Our ref: DOC20/622231
Senders ref: SSD 10344

Response to Submissions – Bella Vista Station Precinct Concept Proposal (SSD 10344)

EES provided previous correspondence dated 21 November 2019 and EES have reviewed the RtS table prepared by GLN Planning dated July 2020 and makes the following comments.

Figure 40 | Baseline flood condition showing flooding during the 100-year ARI to a small portion of the site in the vicinity of the creek.
(Source: Applicant's EIS)

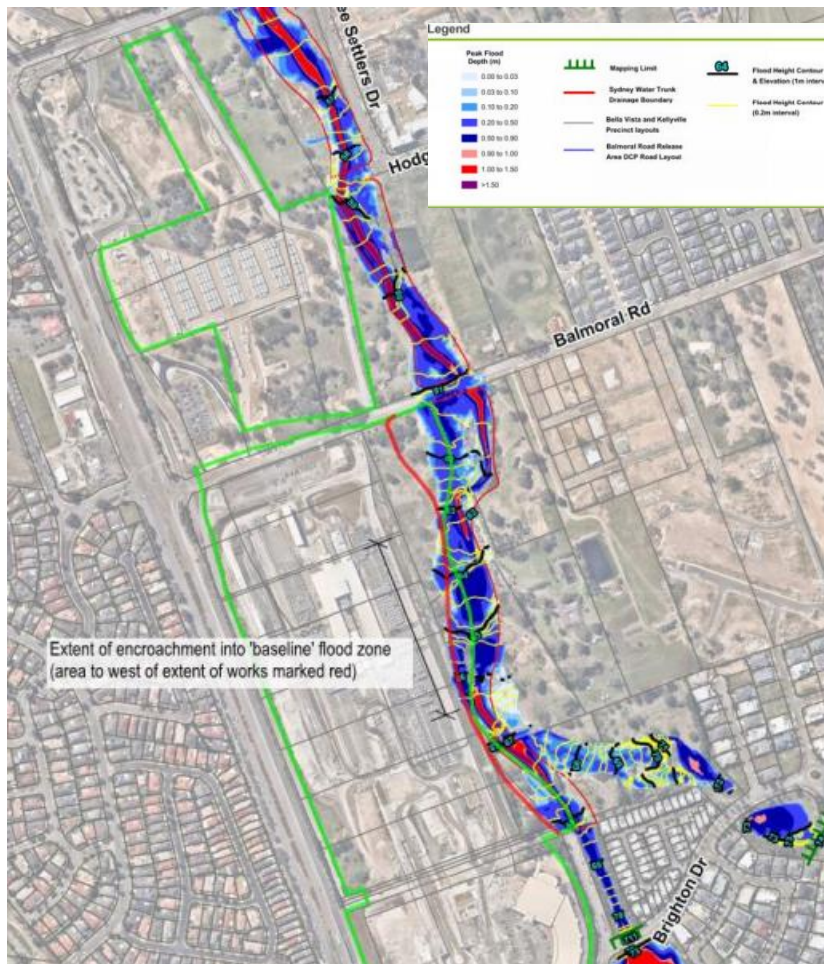
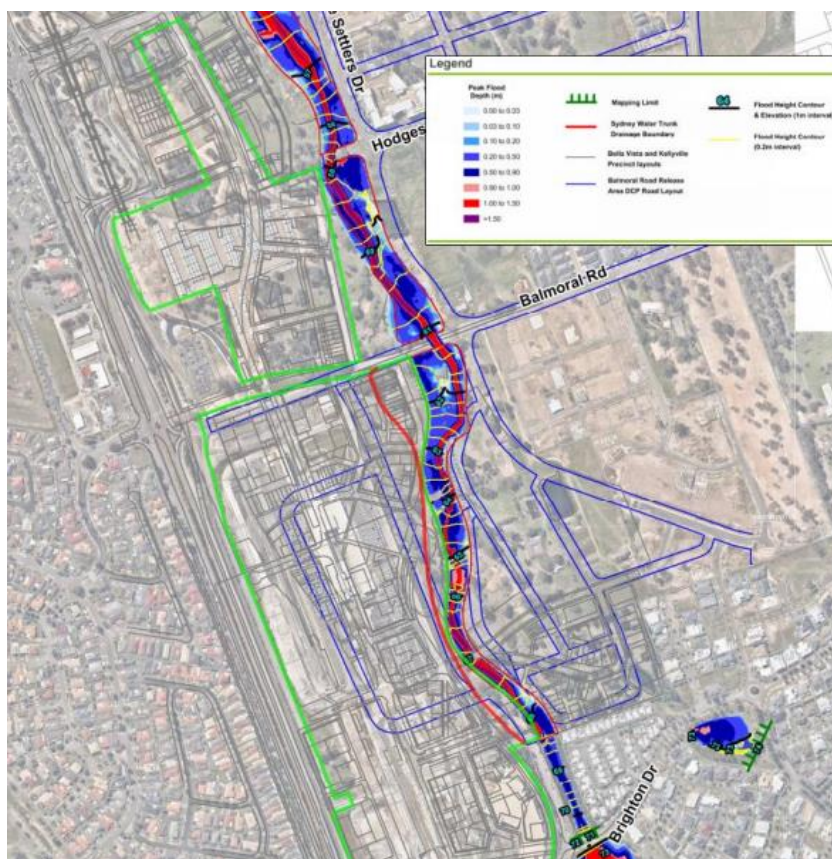
The RtS table refers to a revised Stormwater Management Plan (SMP) as addressing comments on flooding. EES has reviewed Chapter 4 Flood Impact Assessment of the SMP prepared by Stantec dated 9 June 2020, and it does not address EES's previous comments provided in November 2019, and from a floodplain risk management perspective, it is considered inadequate.

The purpose of the flood impact assessment is to address floodplain risk management aspects for the full range of flooding including the emergency management response. Undertaking a flood study up to the flood of design (i.e. 1% AEP) does not provide an understanding of the nature of flooding and the constraints of the land for the full range of flooding. On the other hand, the EMC trunk drainage concept design main purpose is to "...design and document the preferred trunk drainage concept design for EMC...". Both above-mentioned studies are not considered an adequate flood impact and risk assessment.

Accordingly, EES previous advice is still relevant and the Flood Impact Risk Assessment should address the following dot points:

- outline existing flood information, for the full range of flood including the probable maximum flood, based on council's flood information or other relevant studies or historical information where available to address pre-development state

- identify the impacts of the proposed development on flooding and the flood emergency response of the community
- assess the impacts of flooding on the proposed development and identify management options to manage these impacts
